RE: **RFK Charter School – 4300 Blake Road SW**
Grading and Drainage Plan for Building Permit

File **N10-D006**
PE Stamp: 8/23/13

Based upon the information provided in your submittal received 8/29/2013, the subject Grading and Drainage plan cannot be approved for Building Permit. The following comments need to be addressed prior to approval:

PROJECT NUMBER: 20-1007 MEC-10-041  
CAD FILE:   
DRAWN BY: JMJ  
CHECKED BY: VAM  
SHEET TITLE:   
SHEET NO.:   
SHEET TOTAL:   
GRADING AND DRAINAGE PLAN  
C-101R

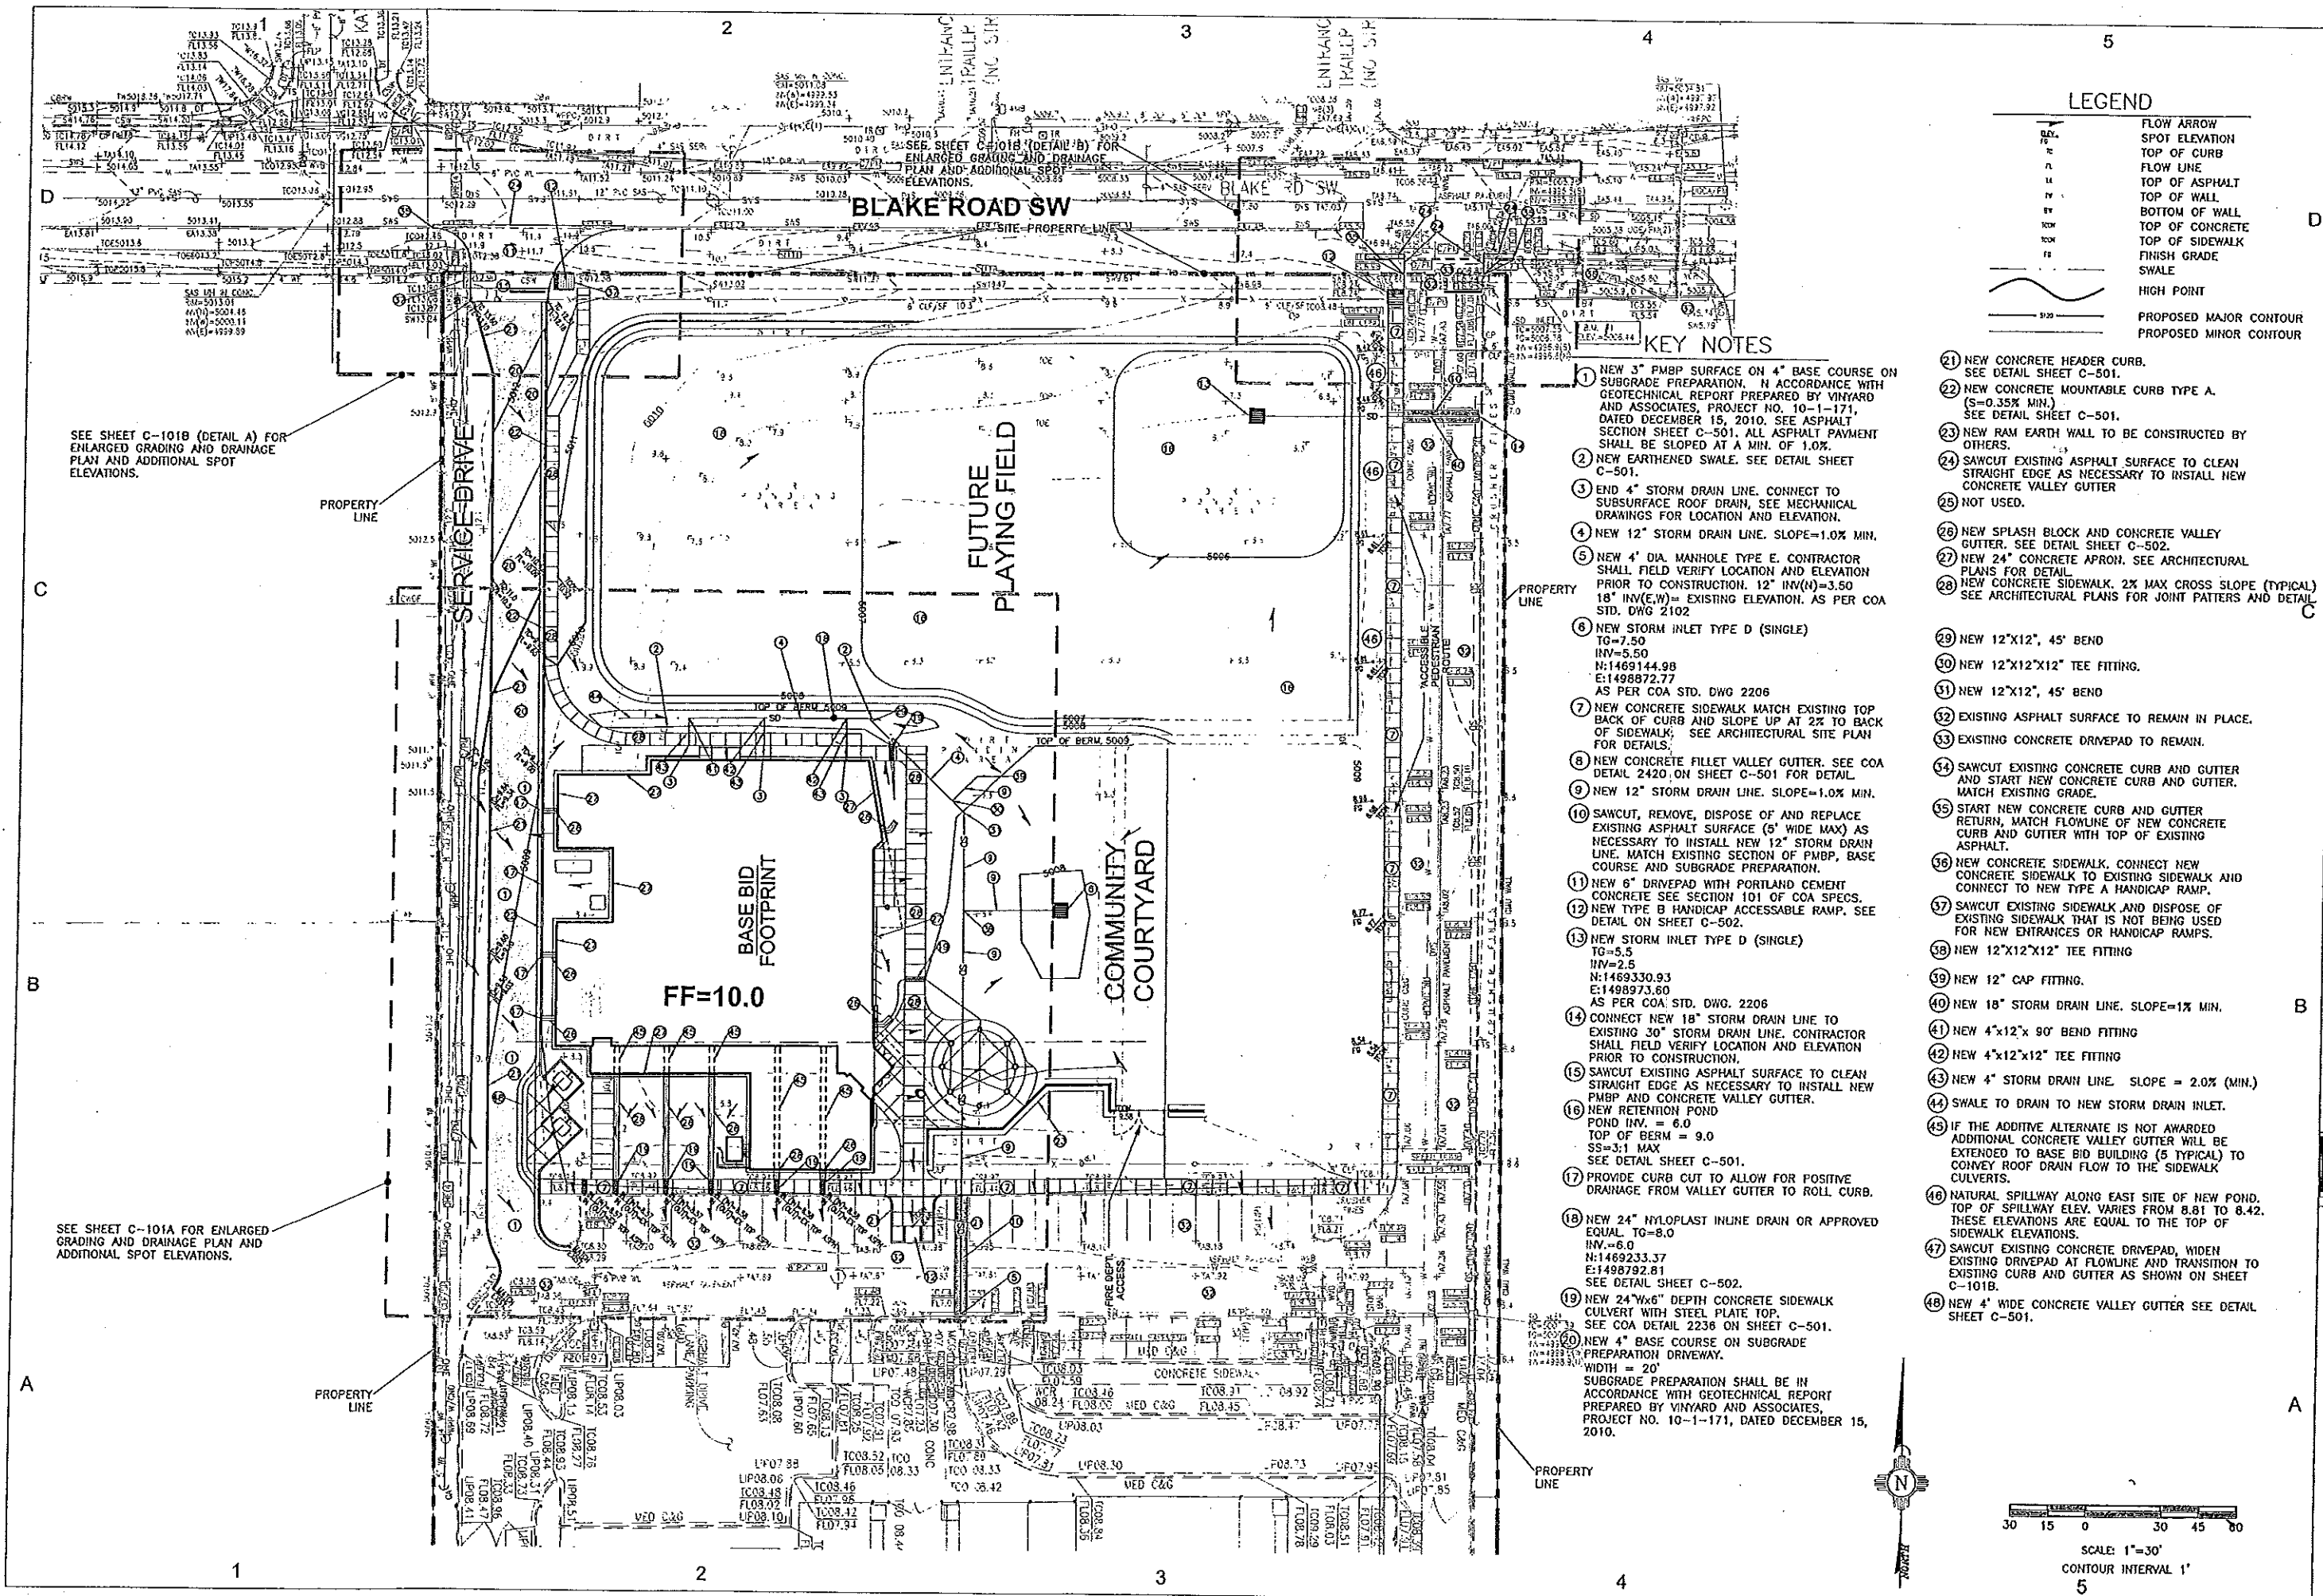
2. Legend symbology does not match the plan (e.g.-“TS” vs. “SW” for Top of Sidewalk grades).
3. Identify the site Property Line on C101.
4. C101: The pond at NE corner of the site is stated to be a Retention Pond with an invert elevation of 5003.0 and a Grate Elev. Of 5005.5, however, the lowest proposed contour shown in the pond is 5006.0. (Ref. Key Note 16)

5. The plan also indicates the berm elevation around the NE pond is 5009.0, but the NE corner of the pond appears to max. out at 8.42, which is the Top of Conc. on the west side of the east entrance road.

6. Spot elevations shown in the graded area east of the Community Courtyard do not agree with the contours on the south edge of the NE pond. John of your office indicated that the area was previously graded for Portable Buildings which were not installed. This plan should reflect accurate, existing conditions.

7. Key Notes 14 and 40 do not agree on the size of outfall pipe from the pond.
